Current Zoning: R-8MF(CD) (multifamily residential, conditional)
Proposed Zoning: UR-2(CD) (urban residential, conditional)

Approximately 12.403 acres located on the west side of IBM Drive, south of Baucom Road, and north of University City Boulevard.

The petition proposes a residential community containing a maximum of 200 multi-family dwelling units and any incidental and accessory uses that are allowed in the UR-2 zoning district.

**STAFF
RECOMMENDATION**

SCHEMATIC SITE PLAN

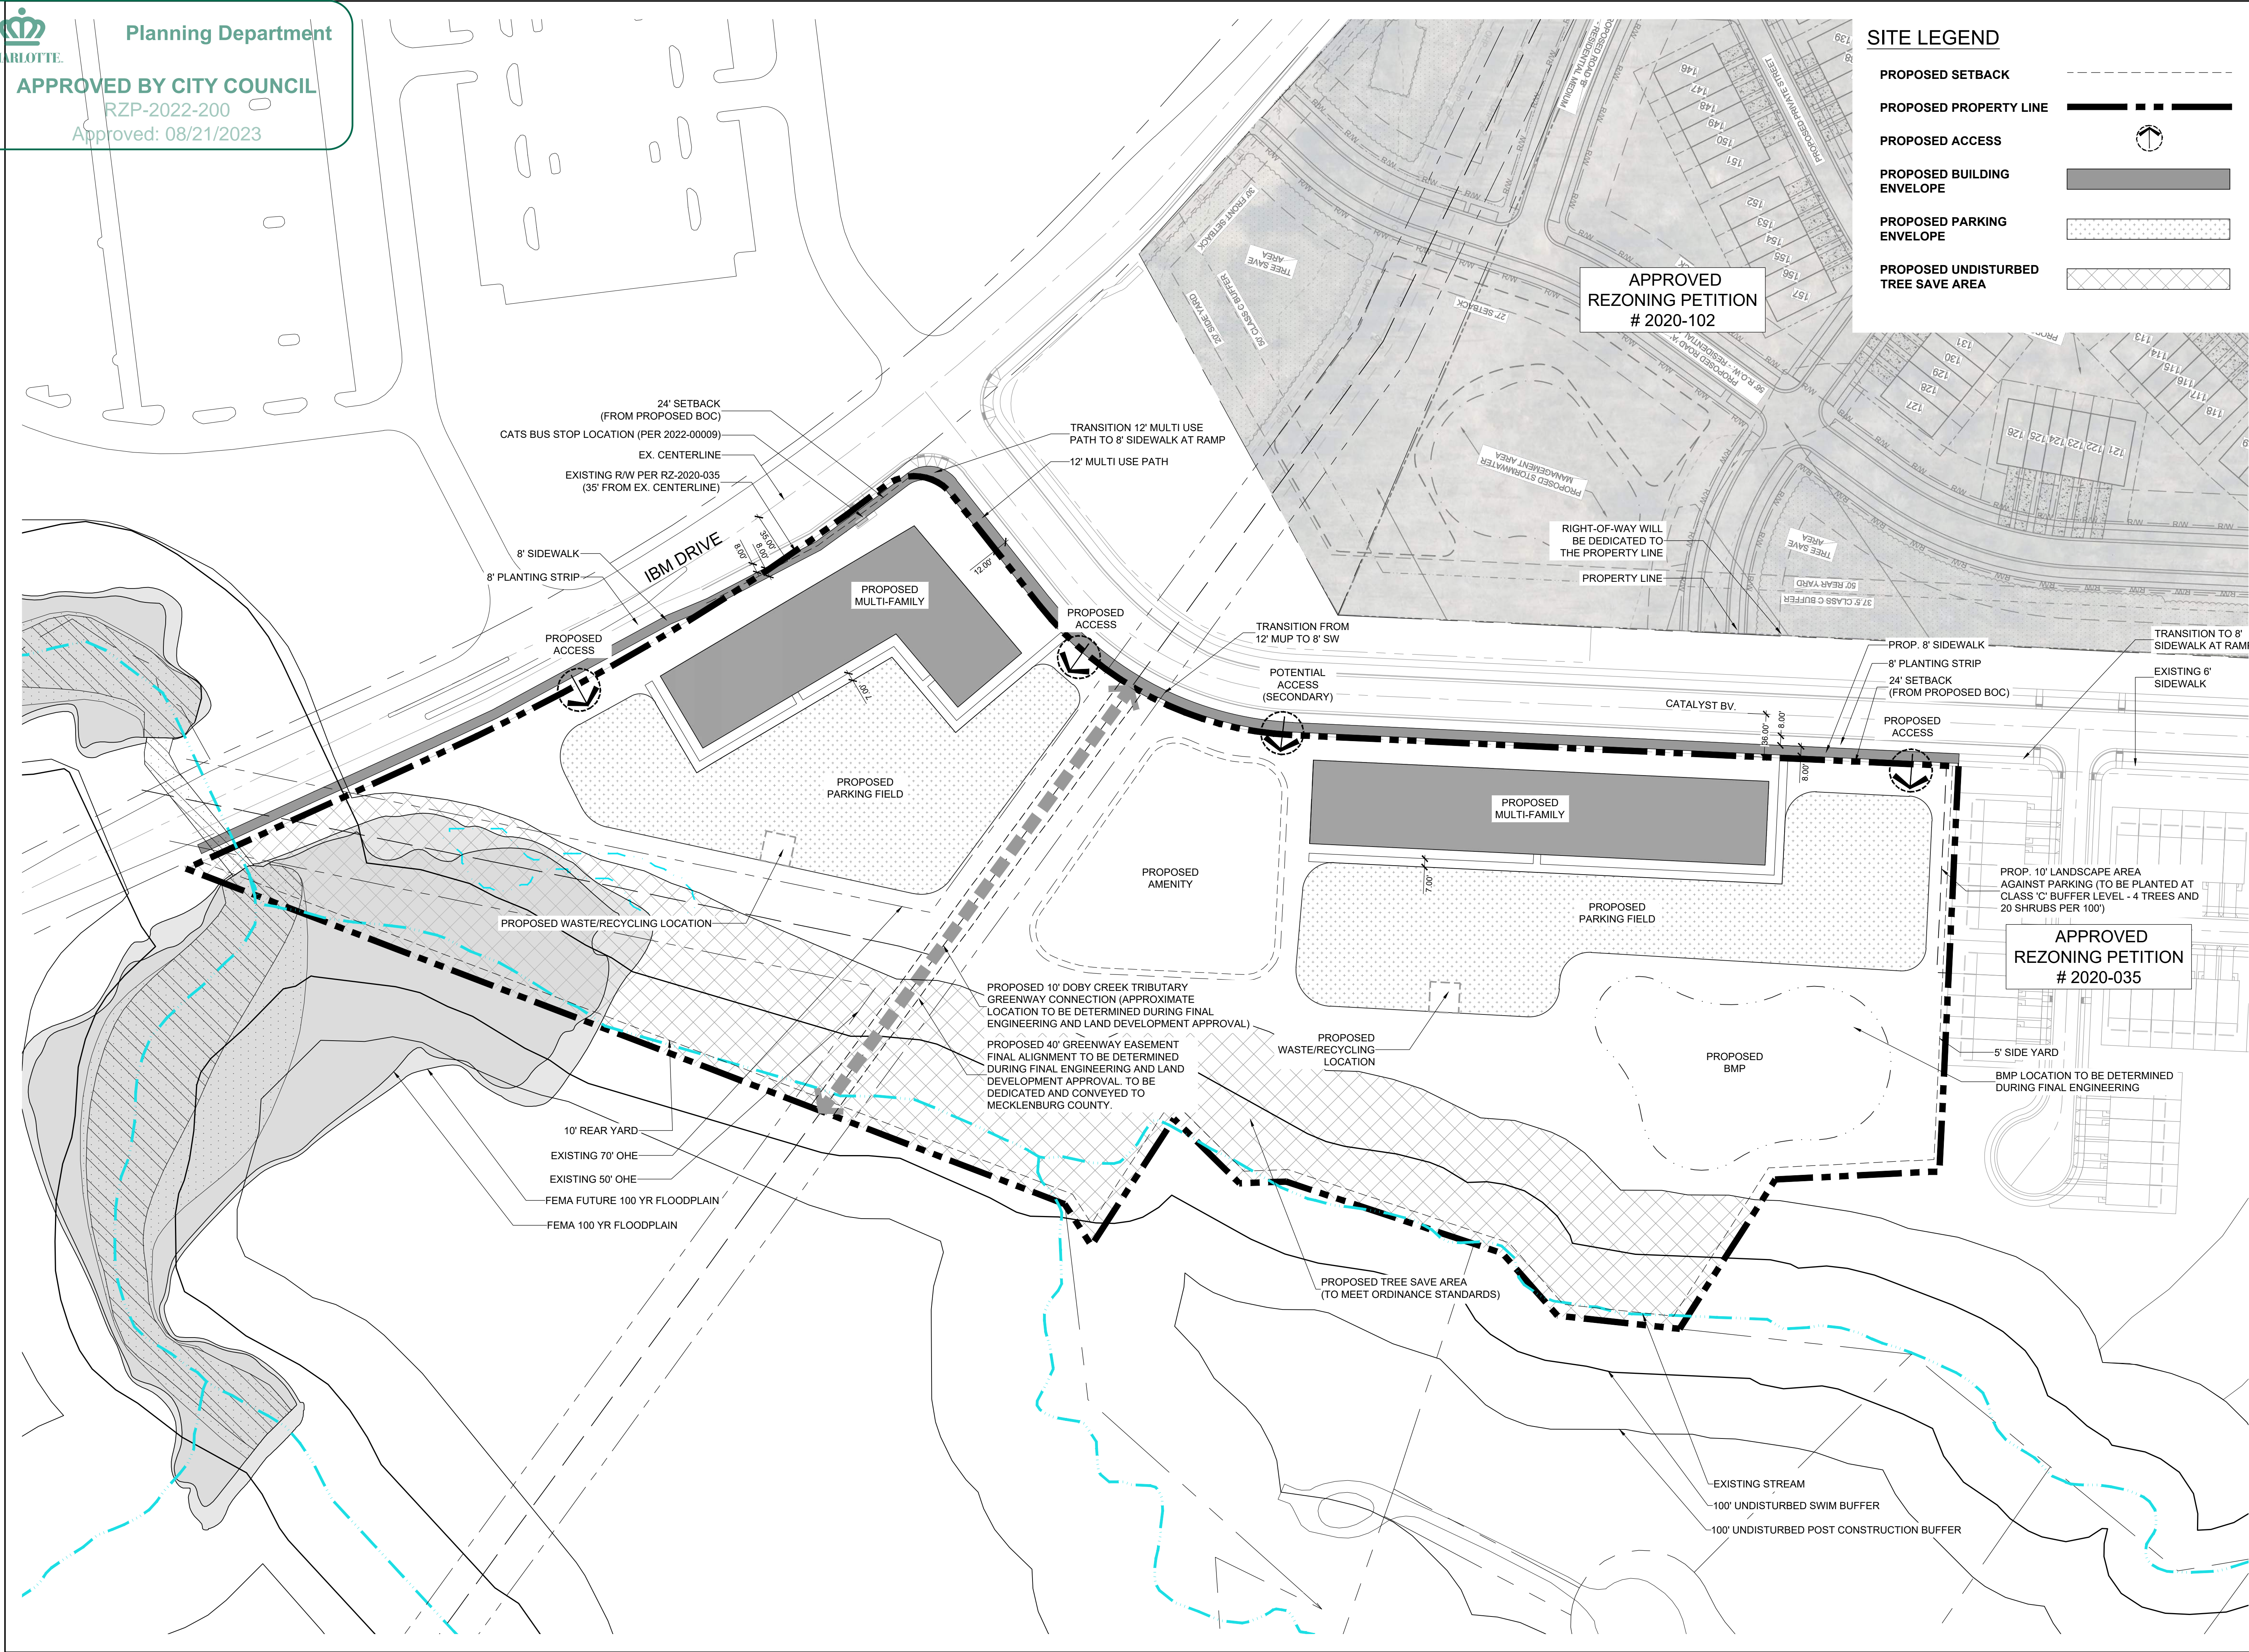
1. ~~Revise site plan and conditional note(s) to commit to revising southern access location to align with the adjacent development access or remove from plan.~~ Addressed

2. ~~Easement note should be revised to read: "dedicated and conveyed to Mecklenburg County".~~ Addressed
3. ~~Show tree save area on plans.~~ Addressed
